Memorandum

Re: Re-submittal of Site Plan-DFT _ PR-2024-010784/SI-2024-01164

The following memo provides responses to DFT staff comments for the SOMOS Affordable Housing Plan, Site Plan-Administrative application heard on August 21, 2024. Staff comments are in italic followed by the Applicant responses.

**BUILDING ELEVATIONS -
DFT SUBMITTAL**
SHEET NUMBER

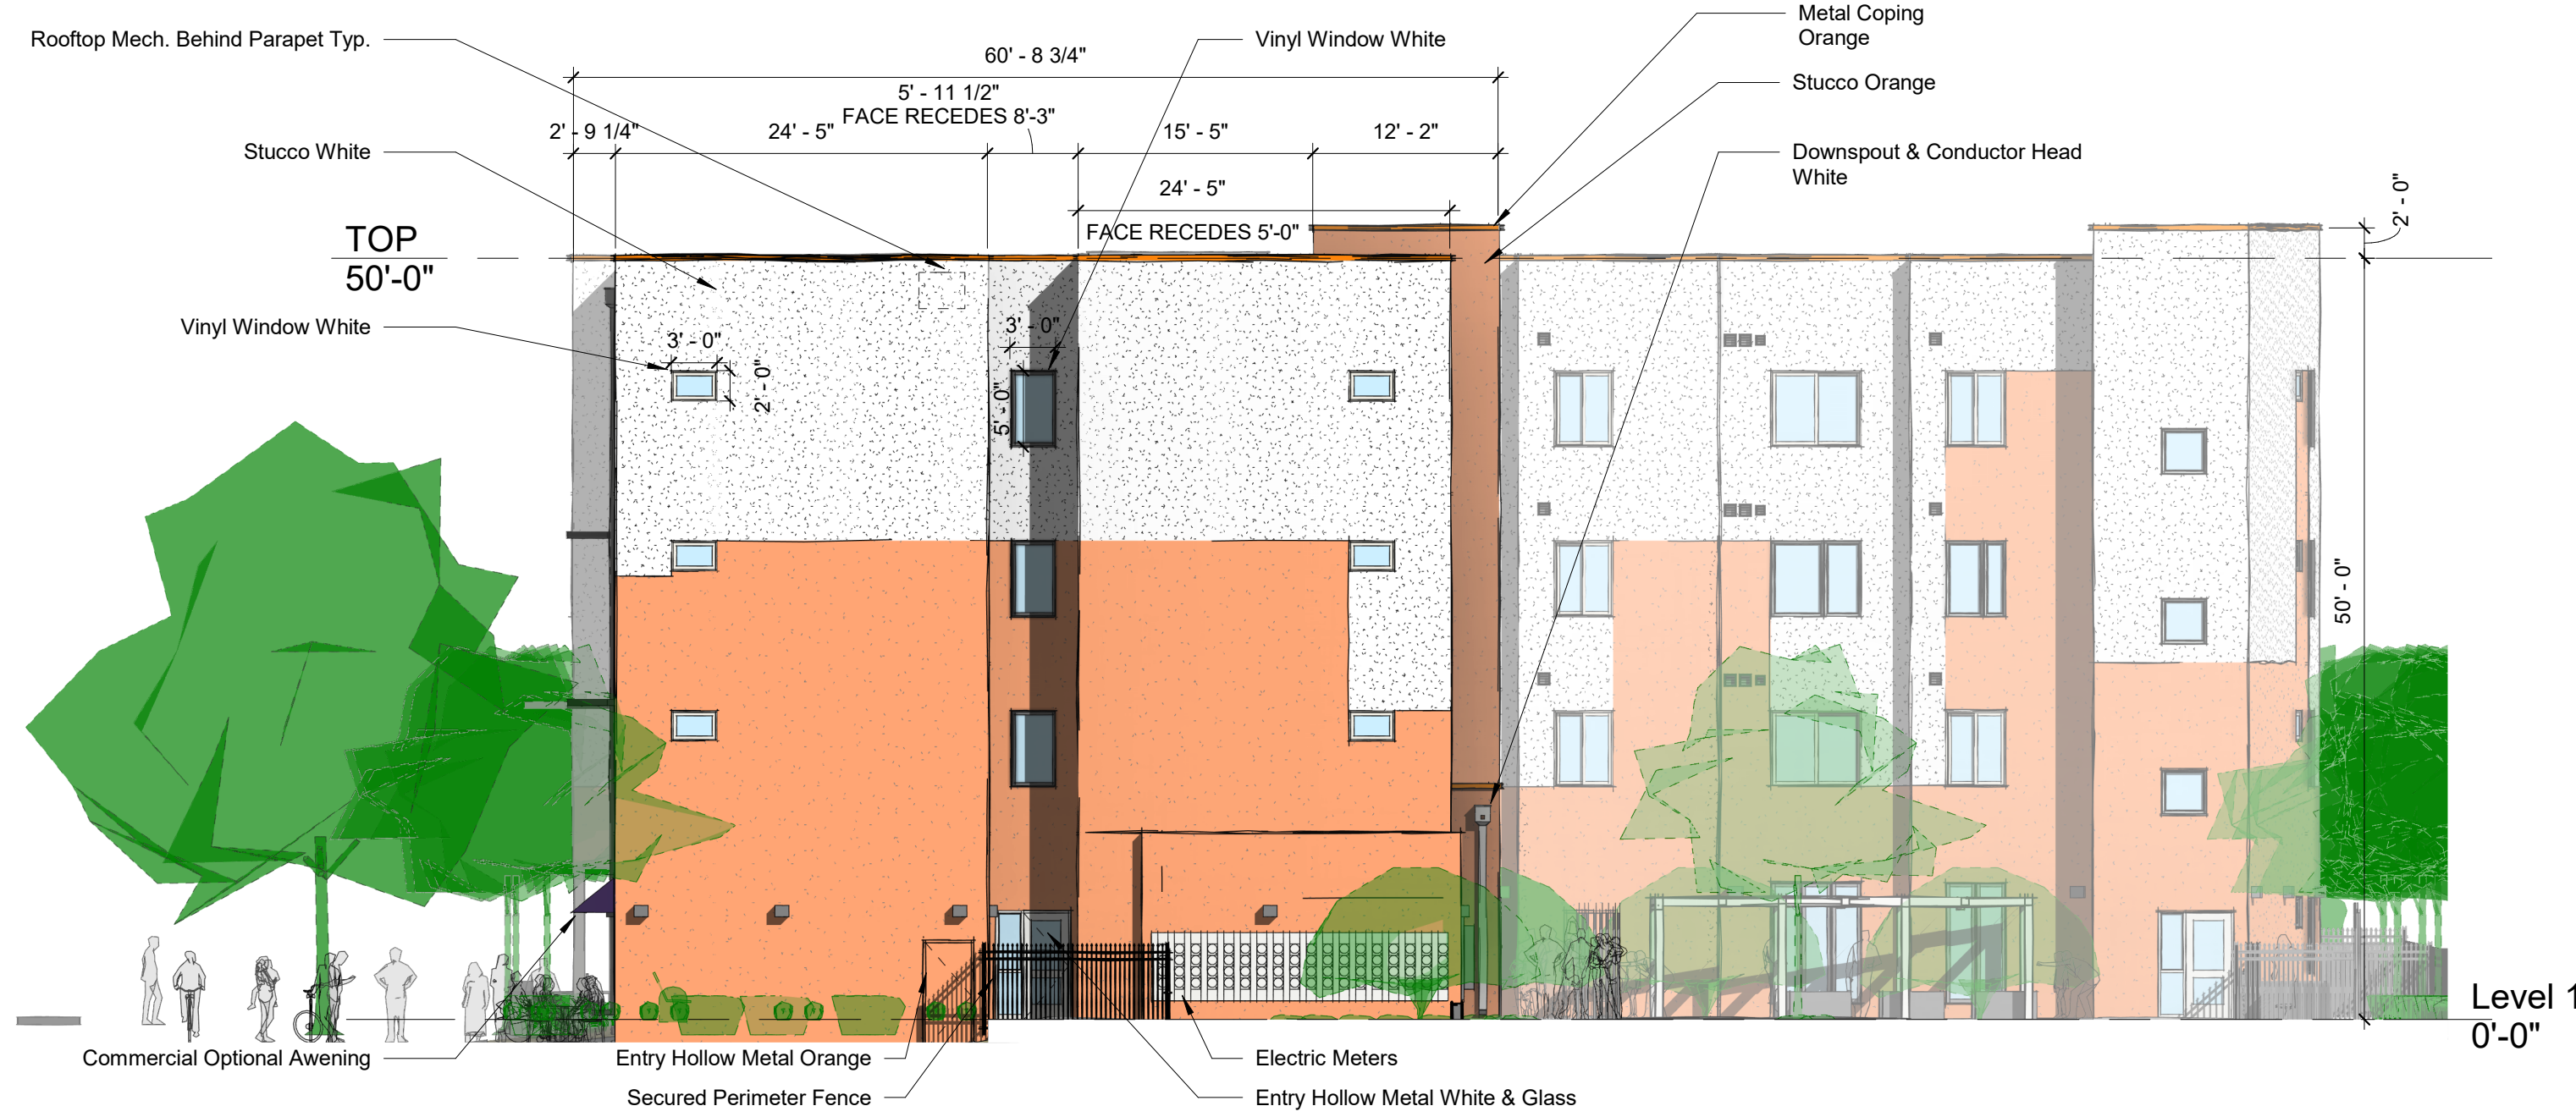
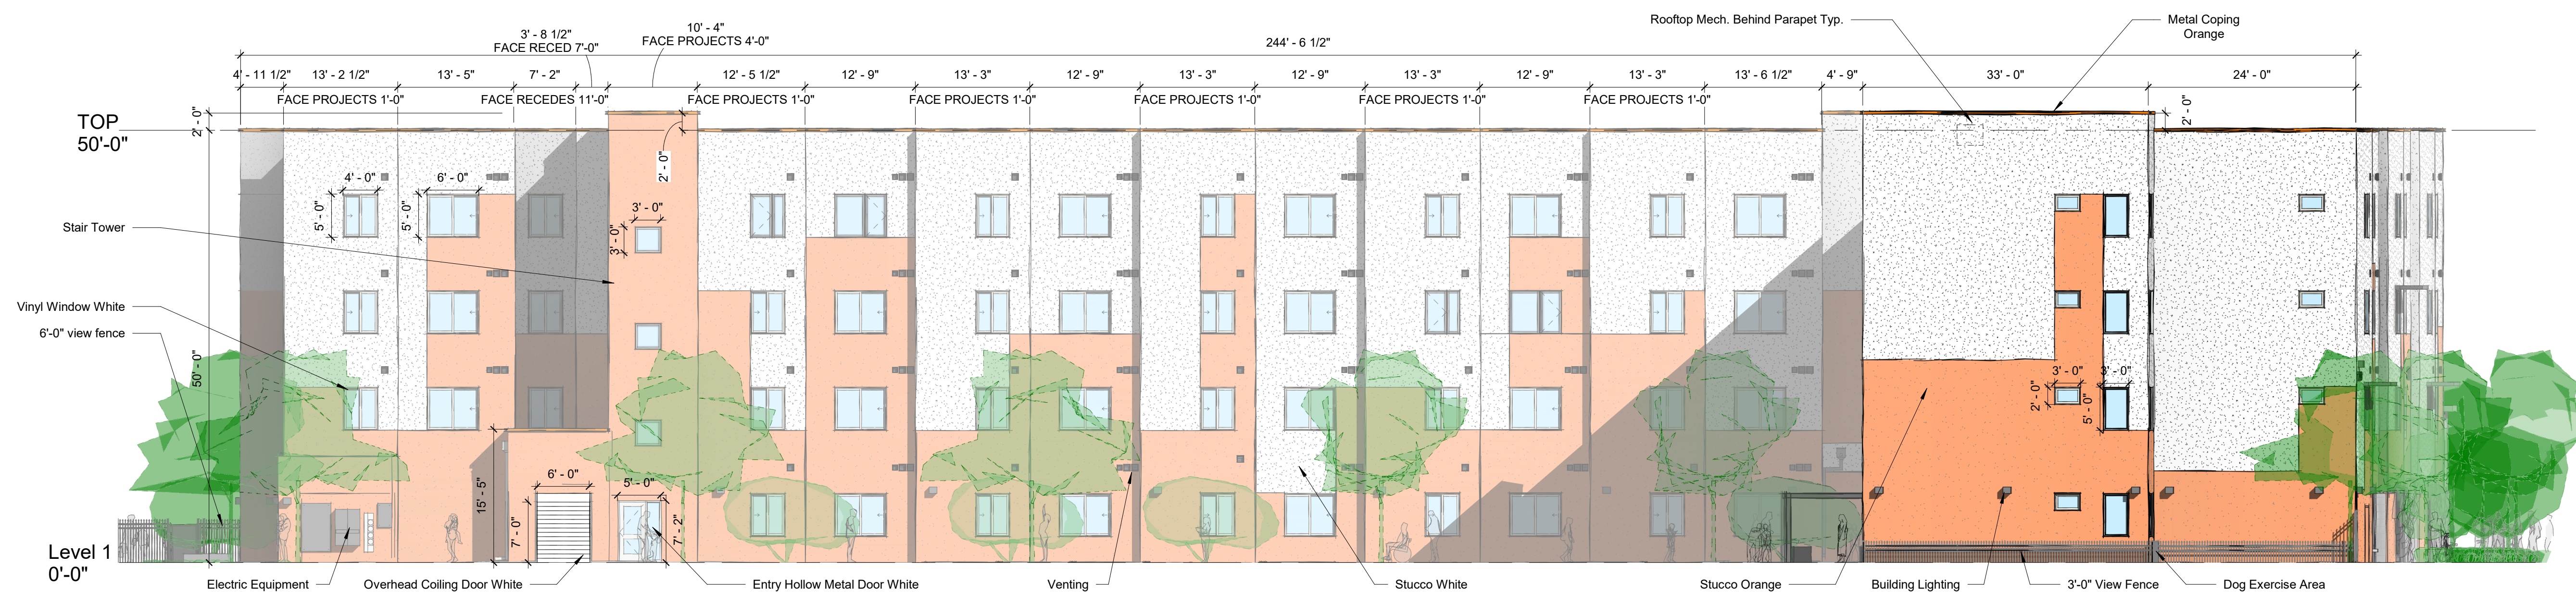
For heat mitigation along west-facing facade, more awnings are required especially for the second and third floors.

1. *In new residential and mixed-use development, windows on the upper floors shall be recessed not less than 2 inches. **Confirm Compliance. Note must be added to the elevation sheets.***

Applicant Response: Aluminum awnings over bedroom windows were added to the fourth floor, maintaining the rhythm of the awnings on the lower floors (see Elevation Sheet SP-8).

Applicant Response: Note e. under General Sheet Notes on the elevation sheet states that upper floor windows are recessed a minimum of 2 inches.

SHEET TITLE
FIRE HYDRANT LOCATION & ACCESS PLAN

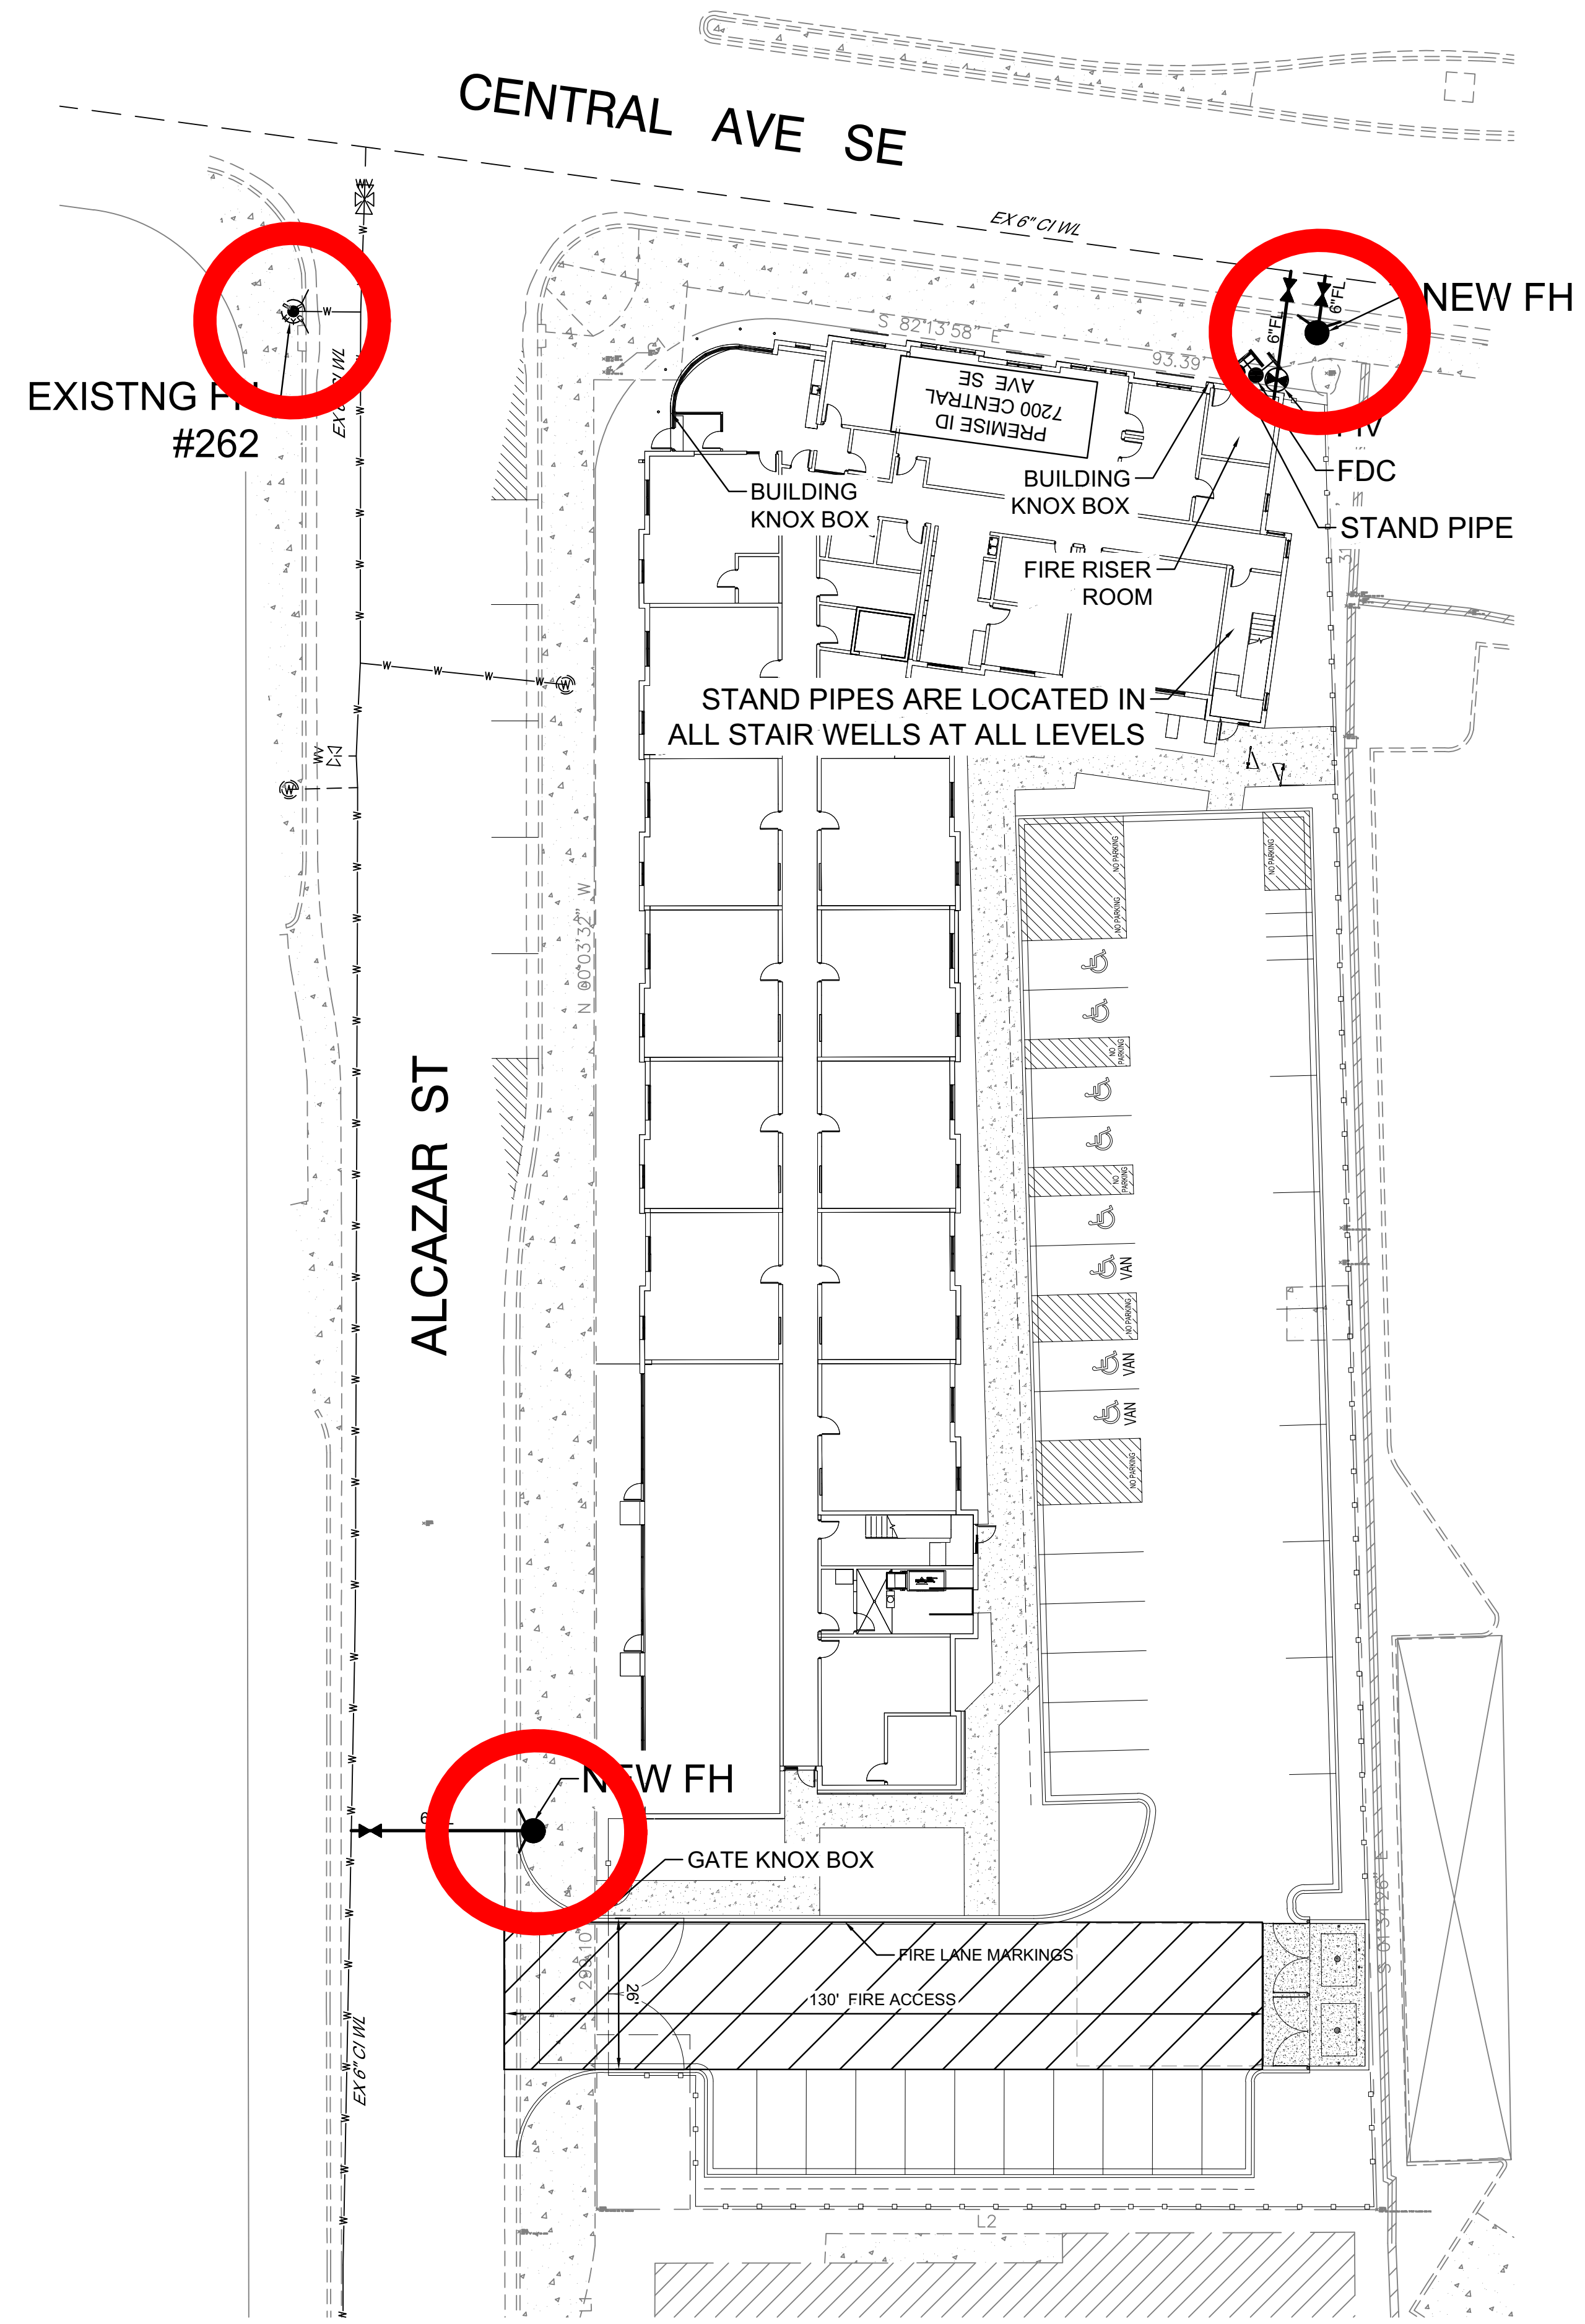
Solid Waste and Fire One approved plans are included in the Site Plan set. Fire one plan must be signed and sealed by a professional licensed in the state of New Mexico.

Applicant Response: The Fire One plan has been stamped.
